Recommendation Report for Planning Permission for Works or Extension to a Dwelling

REF NO: FP/188/21/HH

LOCATION: 20 First Avenue
Felpham
PO22 7LG

PROPOSAL: Single storey side extension and new flat roof to existing extension.

PROPOSED GROUND FLOOR PLAN

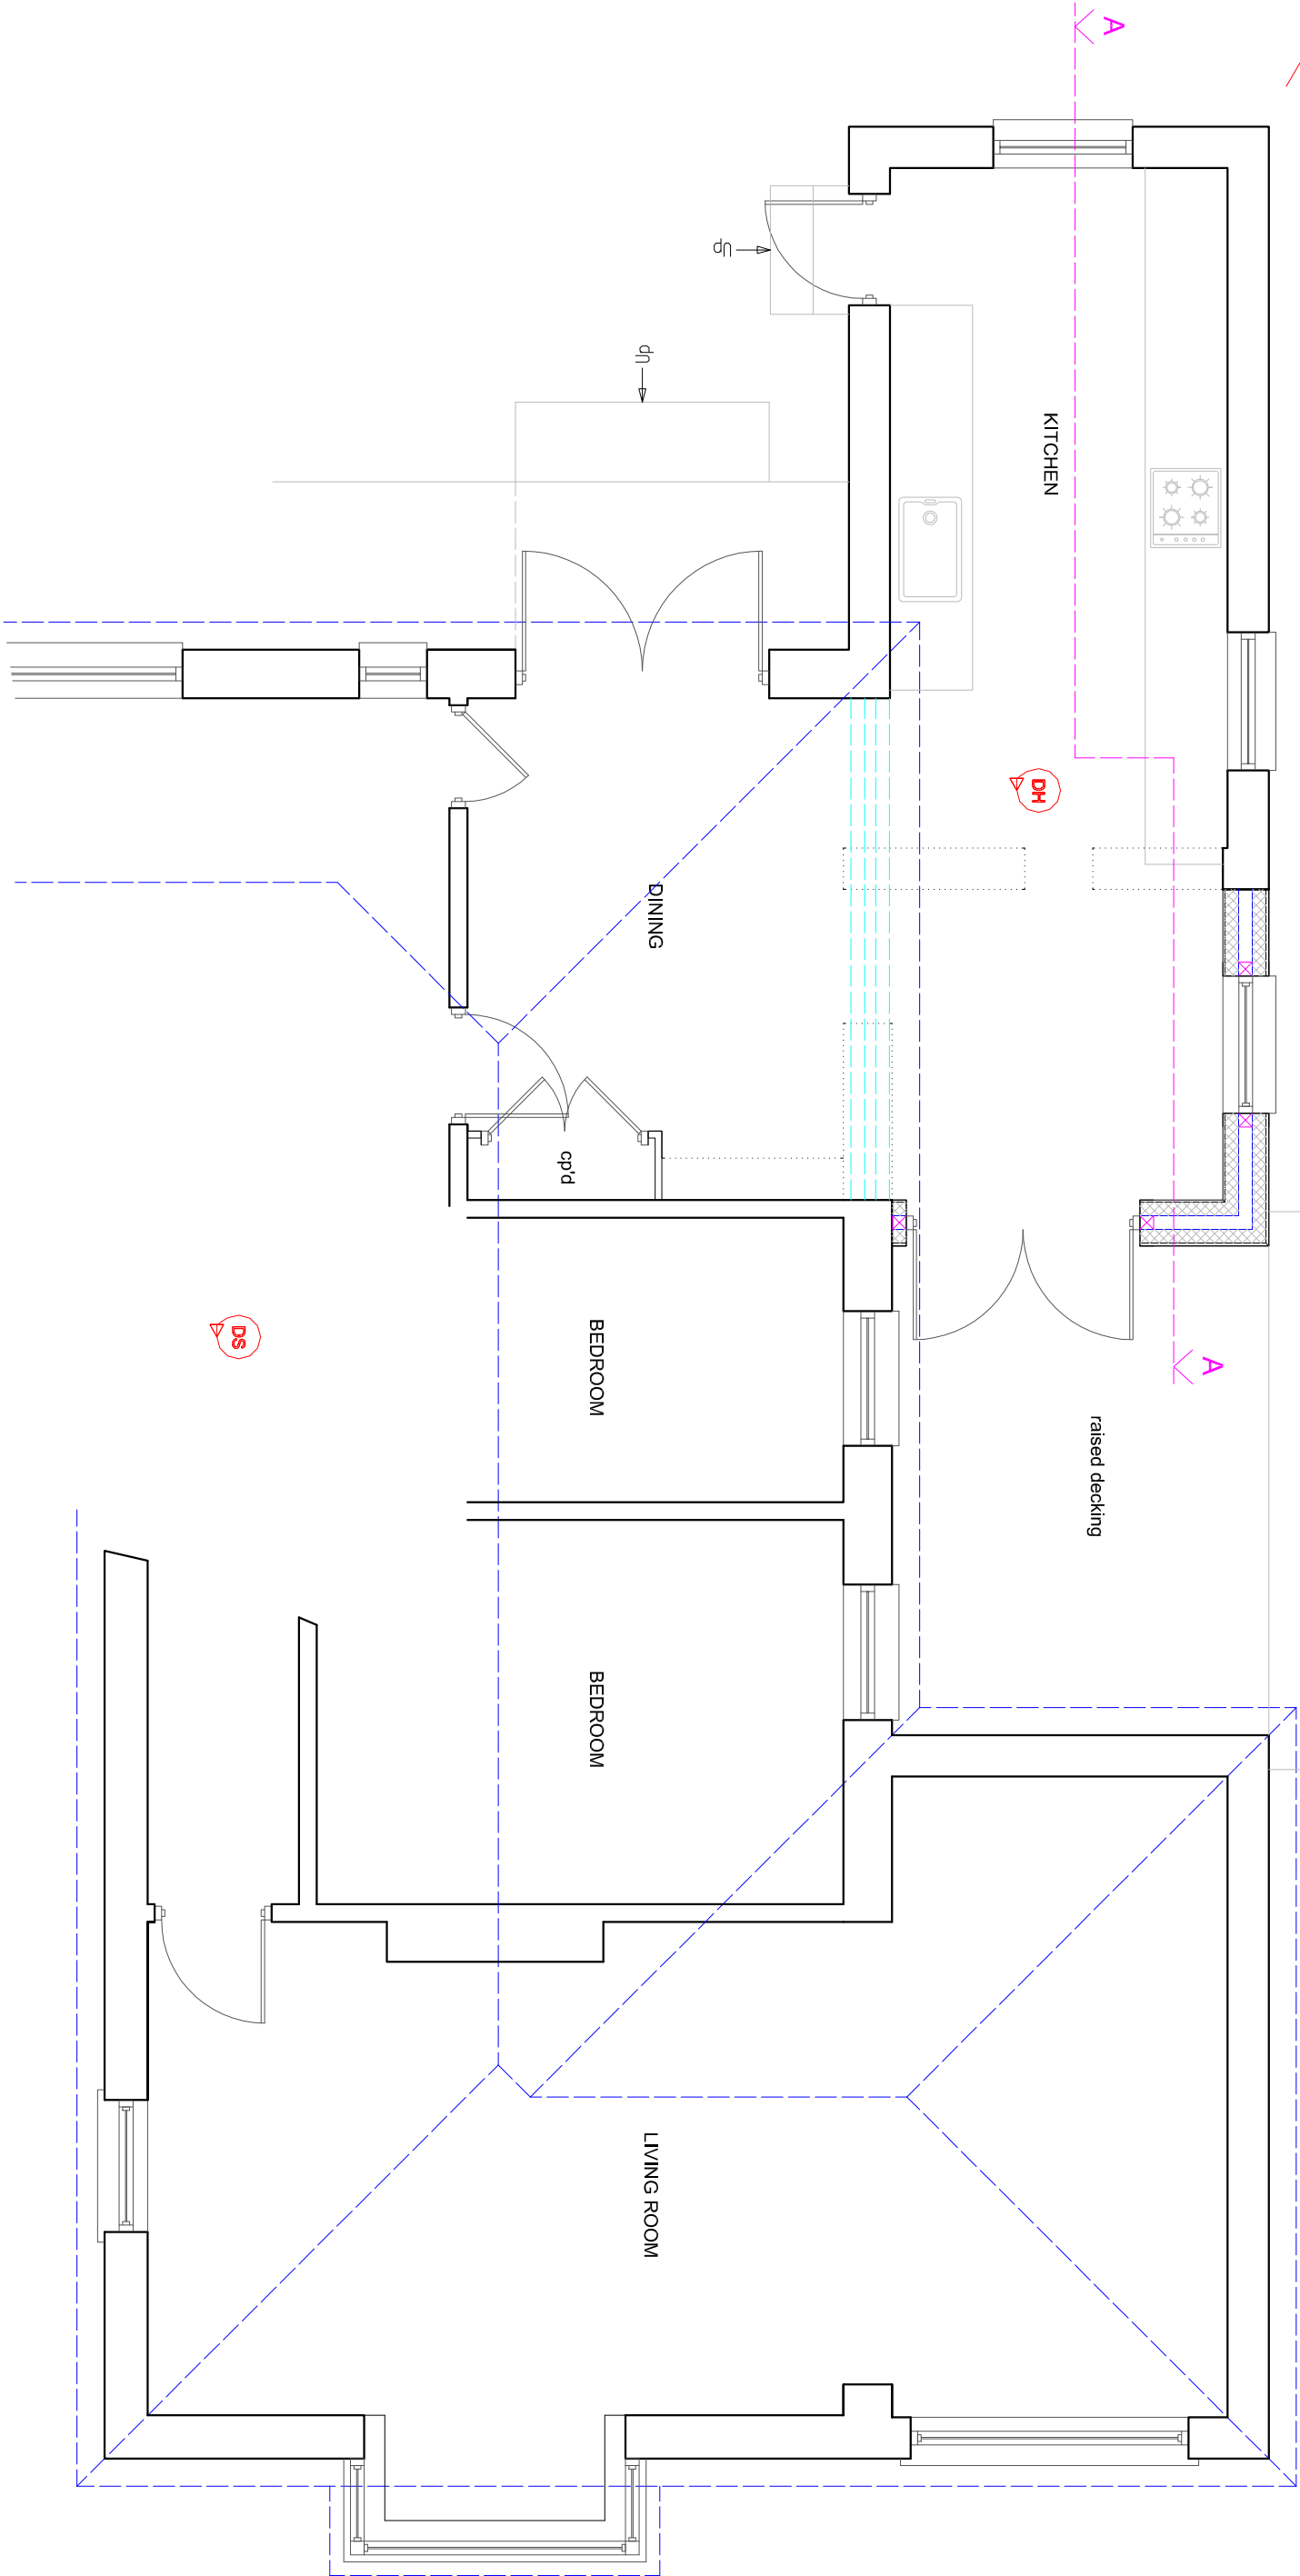
The proposal is located to the northern side and will infill part of the north elevation. The property is located to a corner and has a hedge that runs along the northern side. This screens the development from the street scene and therefore are limited views available of the extension.

The extension is modest in size with a flat roof with a length of 2.6m and a width of 2.75m.

Section M of the Design Guide relates to householder extensions. The proposal is considered to comply with this in such that the design responds to and complements the existing character and appearance of the dwelling. The scale and massing is also appropriate, forming a small infill.

PROPOSED ELEVATIONS

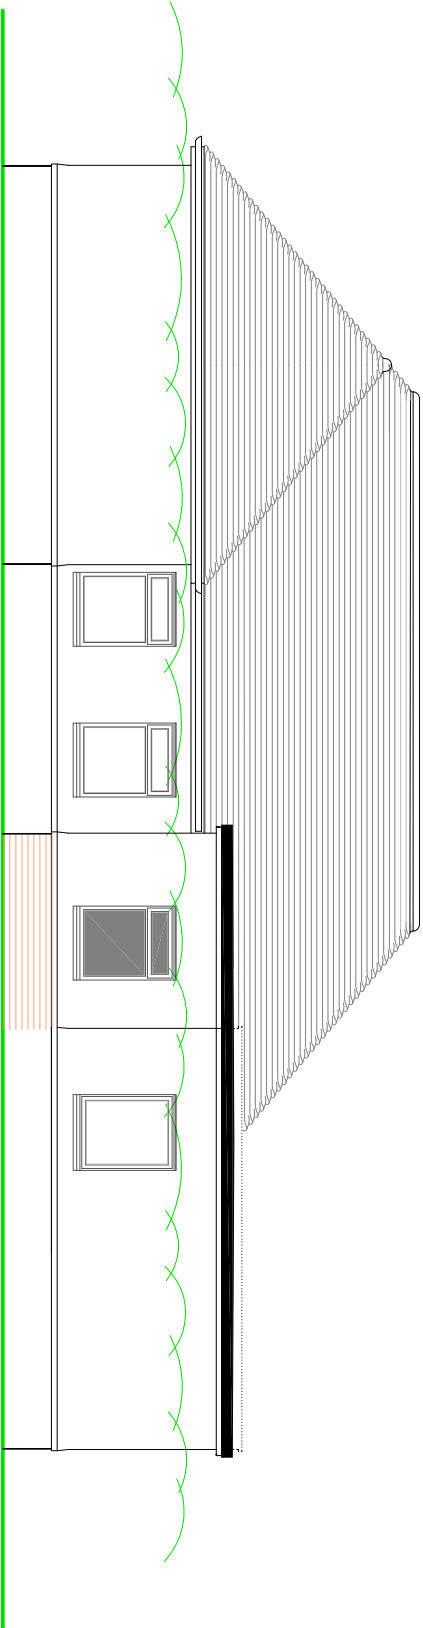
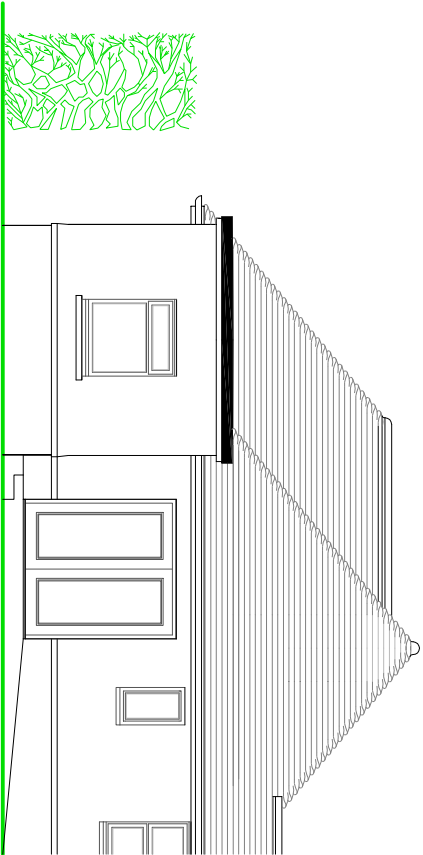
The extension will have a height of 3.1m which meets with the flat roof to the rear of the property.

There is a window to the north and west with views over the garden and street scene and as such, the development will not give rise to adverse overlooking.
